M3 JUNCTION 9 IMPROVEMENT PROJECT

WRITTEN REPRESENTATION OF SOUTHERN WATER SERVICES LIMITED (URN 20036806)

15 June 2023

DRAWING TITLE  
FIGURE 2.7 - THE SCHEME: PROPOSED UTILITY DIVERSIONS  
APFP REGULATIONS 5(2)(a)  
SHEET 1 OF 5  
DOCUMENT REFERENCE 6.2

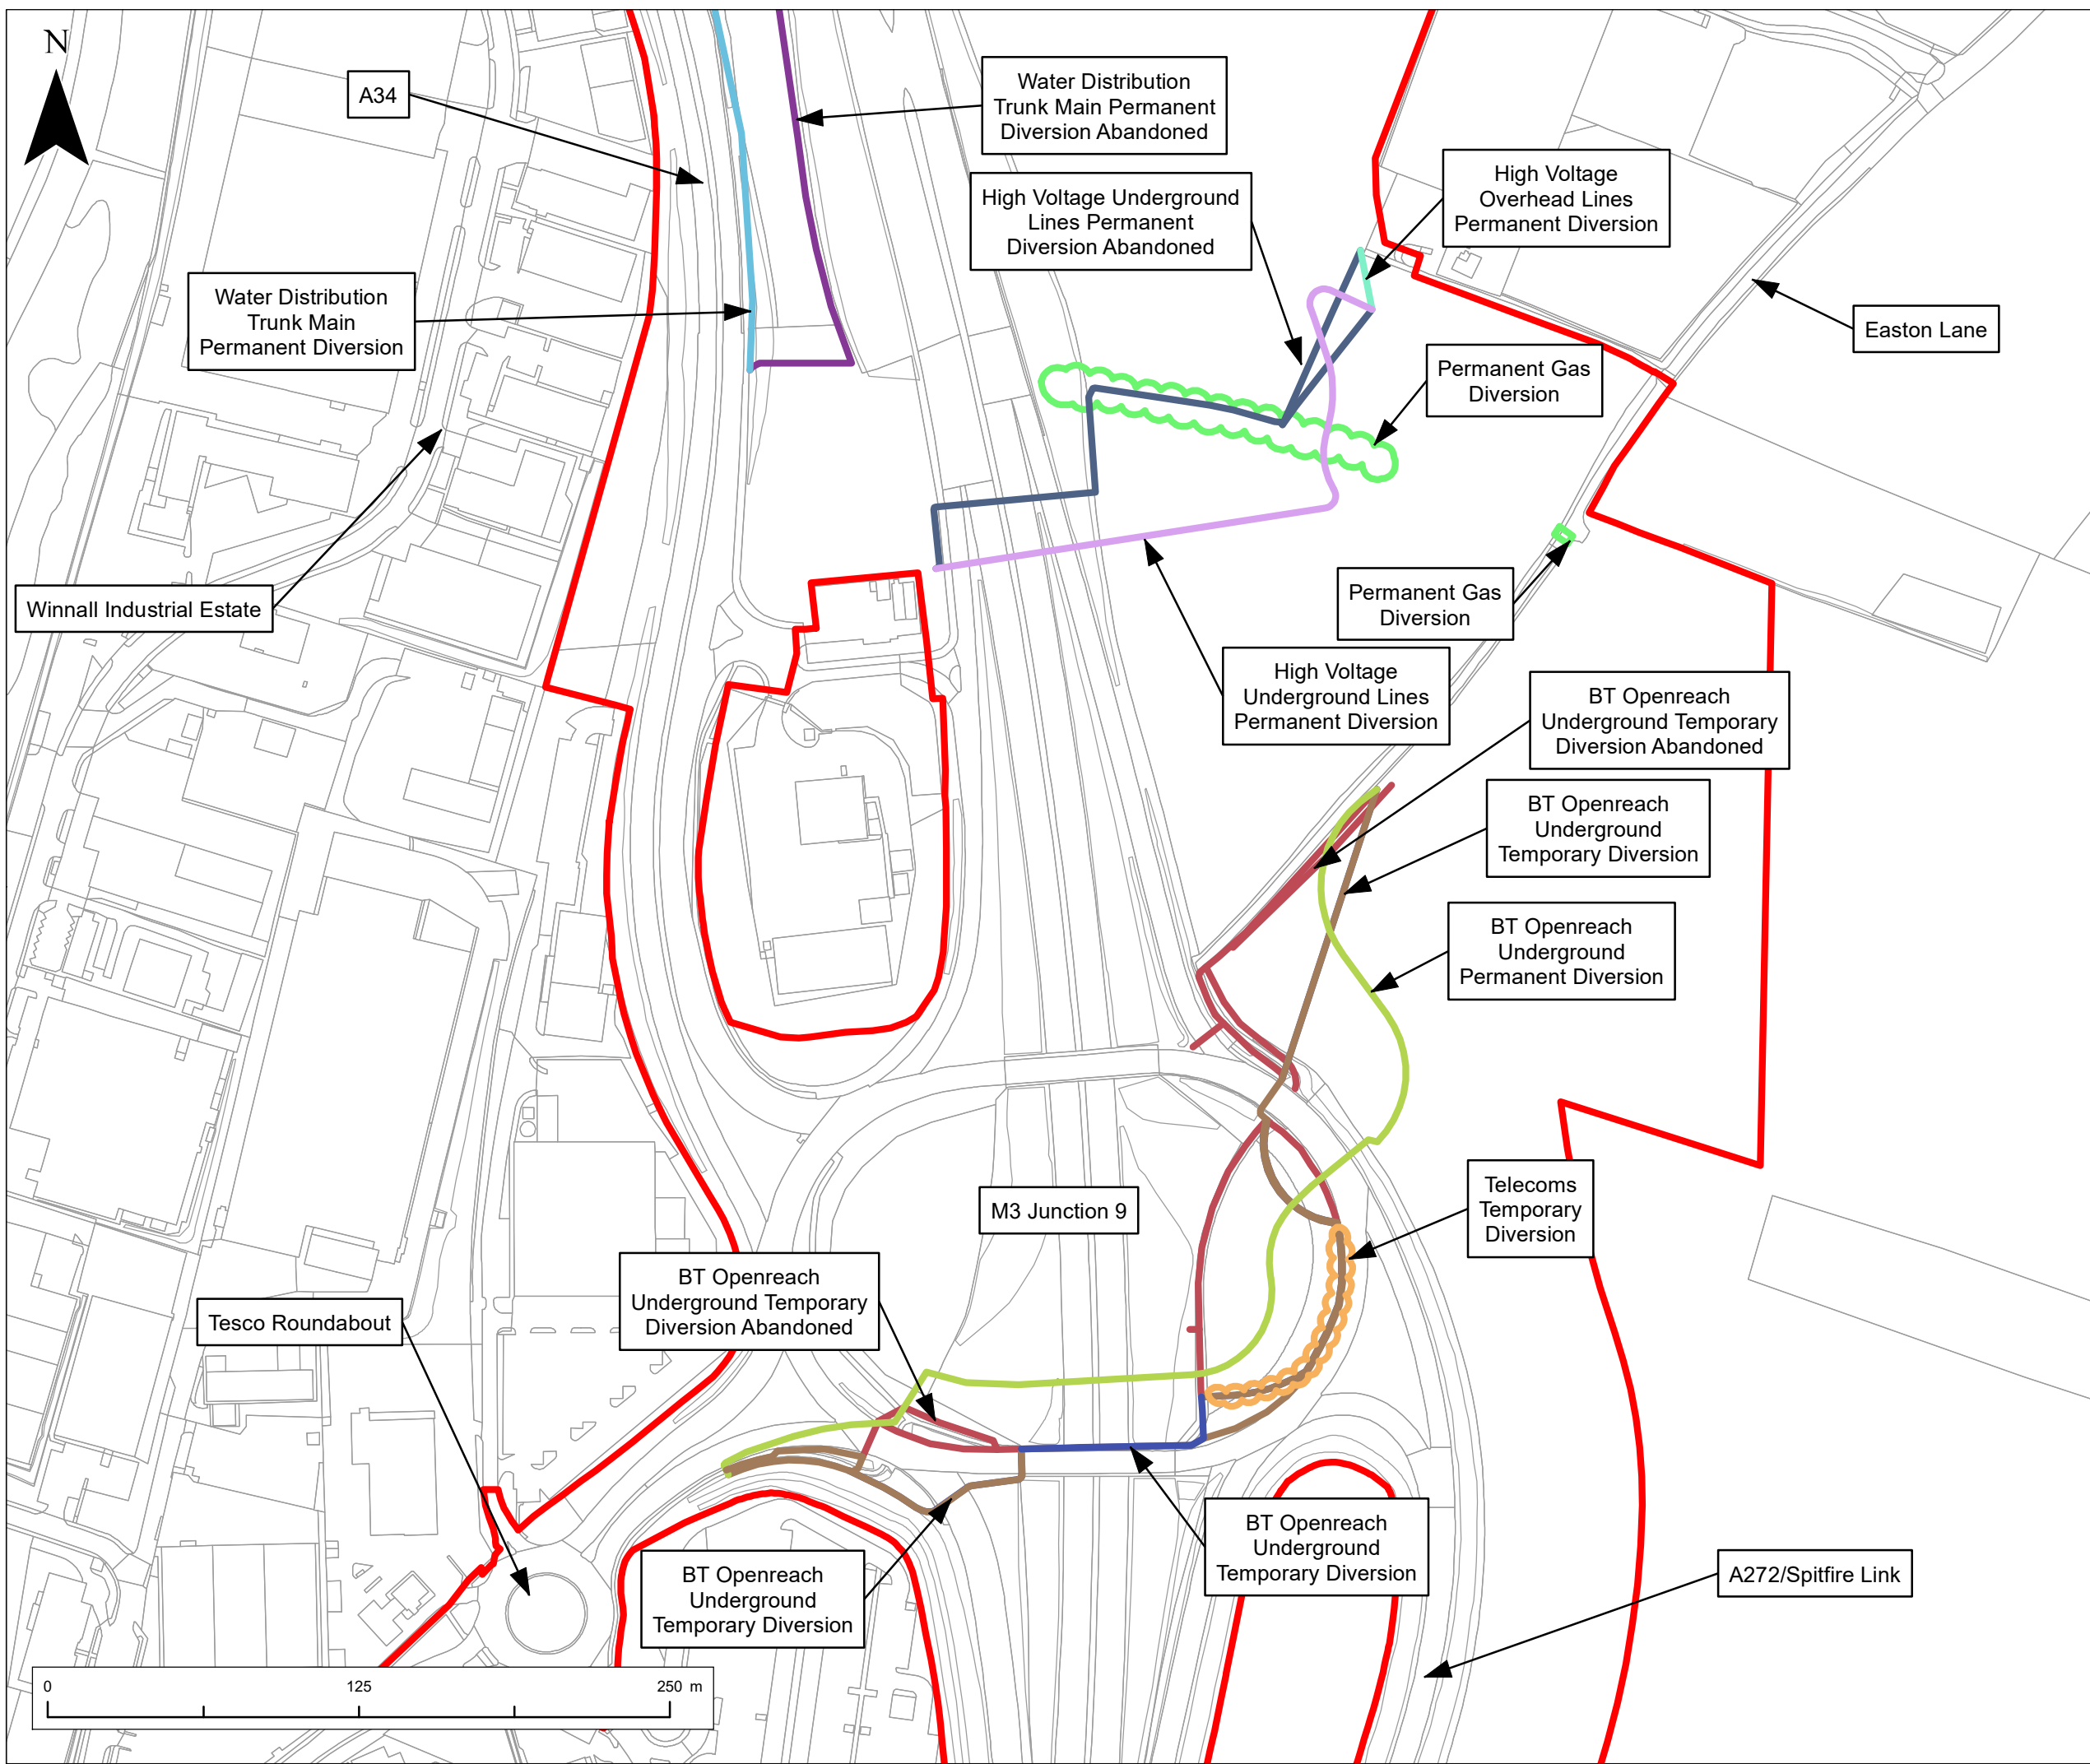
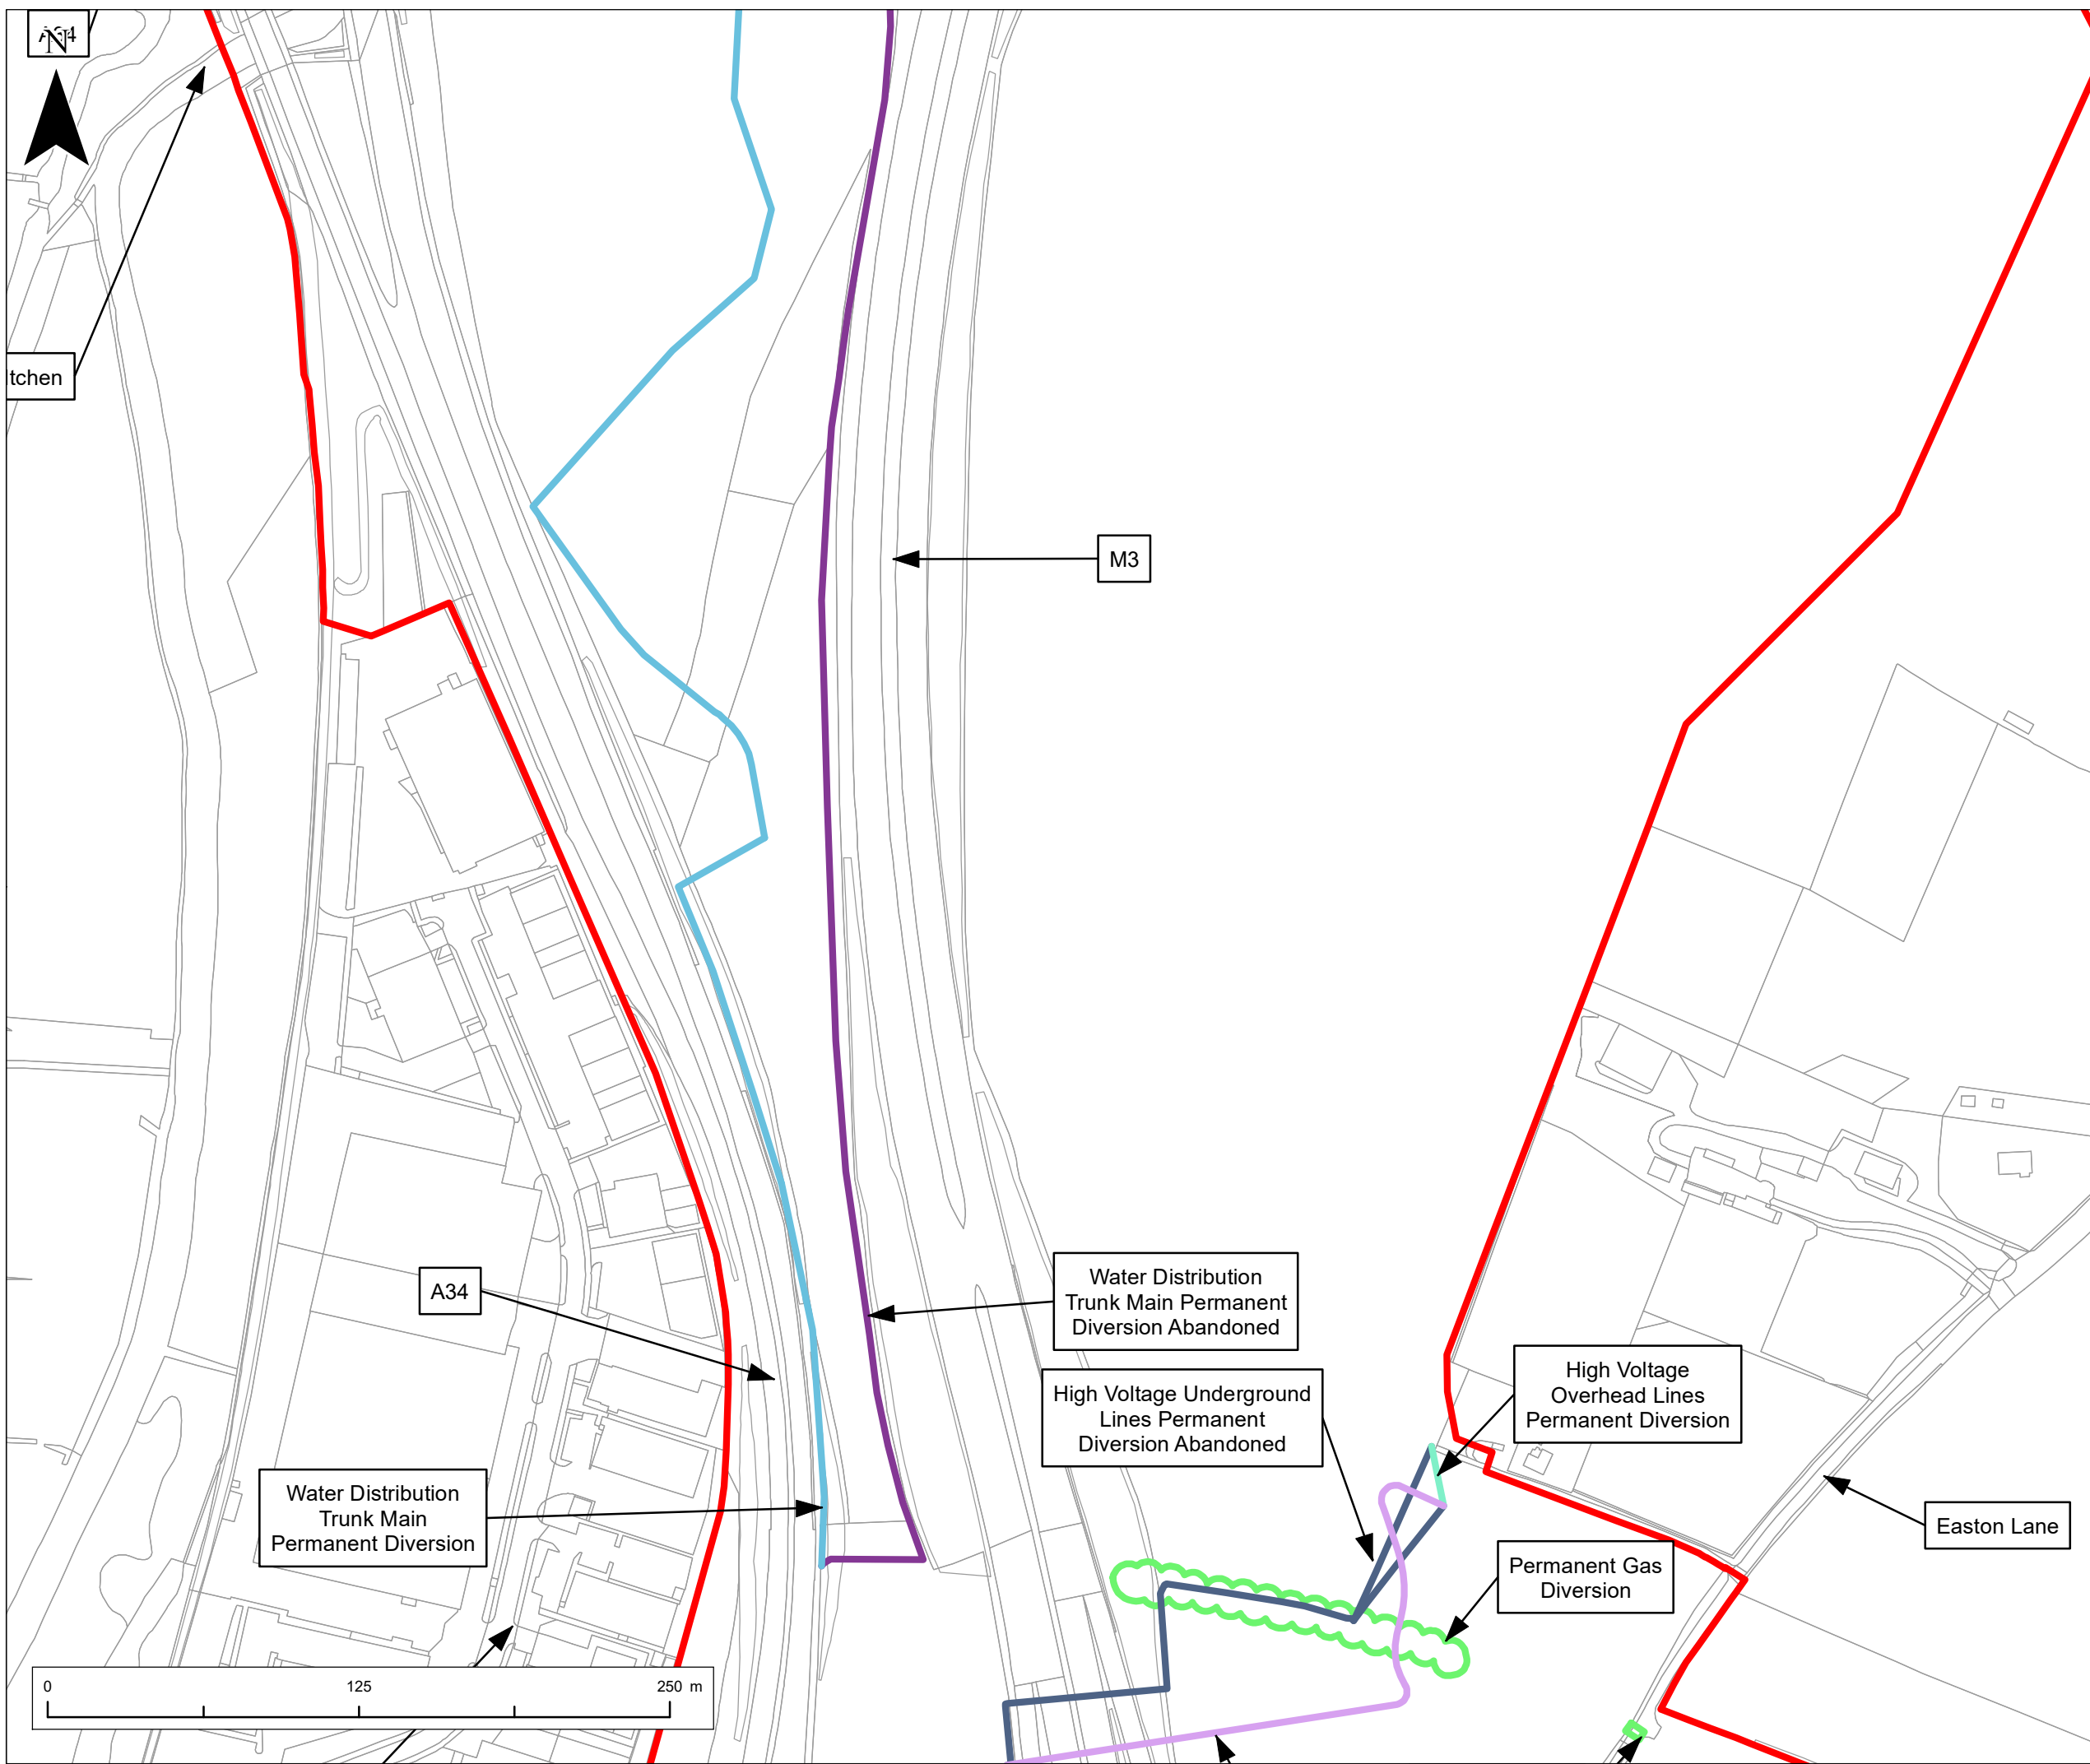
- 4.6. Southern Water notes the proposed diversion of the 300mm D.I (ductile iron) water main and understands that the work will be carried out in two stages, with a temporary main being installed in the first instance. The new main will be laid in 355mm HPPE (high performance polyethylene).

- 4.7. This is a strategic trunk main which serves a large number of properties in Winnall and surrounding areas. As such, it is vital that there is significant engagement with all parties involved with this diversion during the construction phase. In particular, there will need to be close management of the connections to the existing mains network to ensure that the impact to Southern Water's existing customers is mitigated as much as possible, to avoid unnecessary disruption.

- 4.8. The permanent diversion arguably places Southern Water in a worse position as regards future asset access and maintenance, by having two sections of ducted mains and the remainder in highway embankments behind industrial units on Moorside Road, where currently all pipe is in the relatively more favourable setting of agricultural land. Southern Water wishes to discuss this further with the Applicant.
